APP/R5510/W/23/3318295: 35 Bedford Avenue, UB4 0DP

Comments about the appeal statement of London Borough of Hillingdon.

BLOCK PLAN SCALE 1 : 200 at A4
35 BEDFORD AVENUE UB4 ODP
SHOWING PROPOSED ALLOCATION
OF OPEN SPACE BETWEEN THE FLATS
DRAWING: CH/SUNNY/32 9th SEPTEMBER 2022.

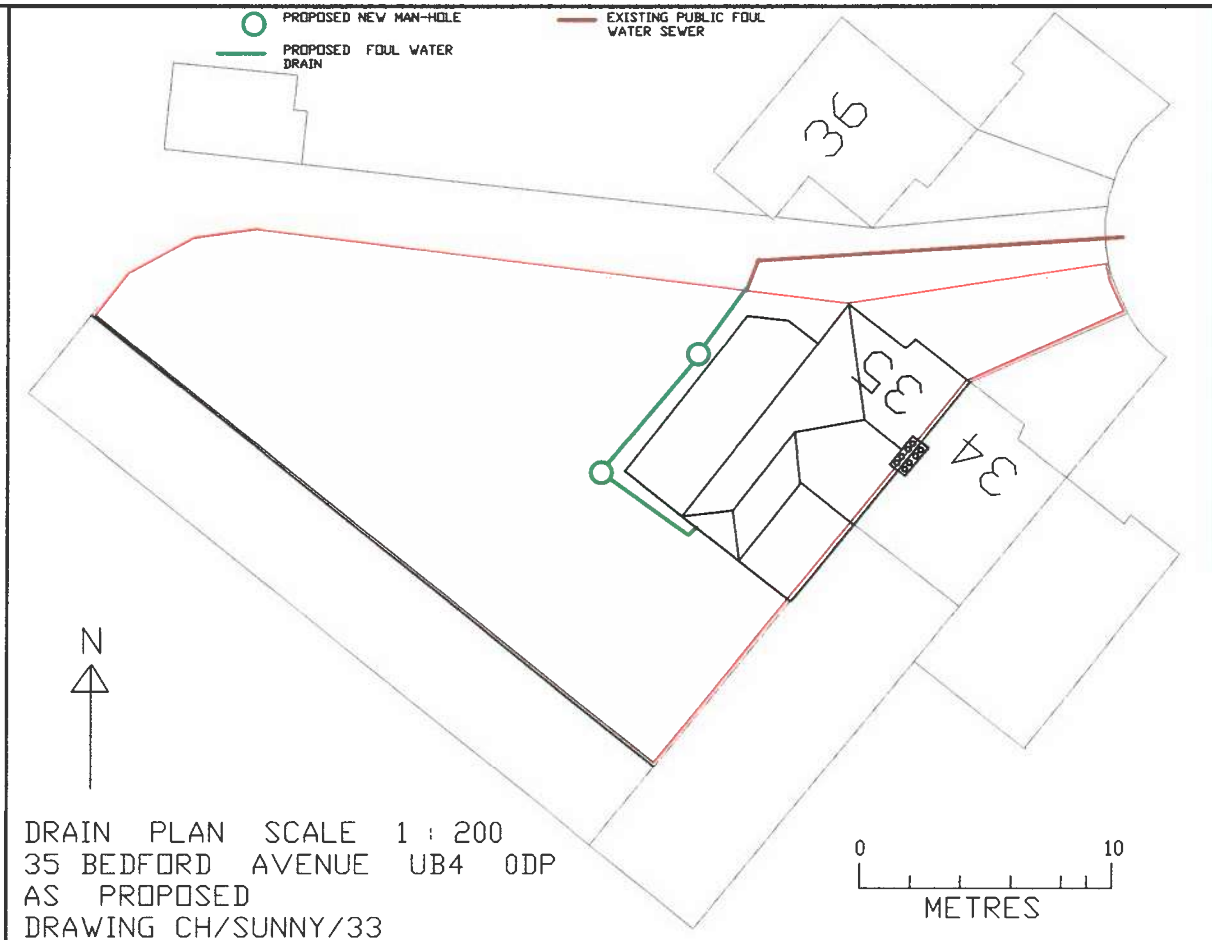
‘No information has been shown as to how each flat would access the rear garden or how the garden would be divided for both properties. The drawings do not demonstrate easy access for both units in and out of the building or into the garden.’

- iv. Adequate amenity space is provided for the benefit of residents: drawing CH/SUNNY/32 dated 9th September 2022 shows the amenity space which exceeds minimum standards set out in the London Plan policy D6 (see my Appendix 2)
- v. Adequate living space standards: the proposed development exceeds the minimum standards set out in Policy D6 of the London Plan

The appellant thinks that statement is incorrect and that submitted drawing CH/SUNNY/32 dated 9th September 2022 shows those matters adequately plus there is the private right of way between buildings numbered 35 and 36 and combined those proposed and existing features provide for easy access.
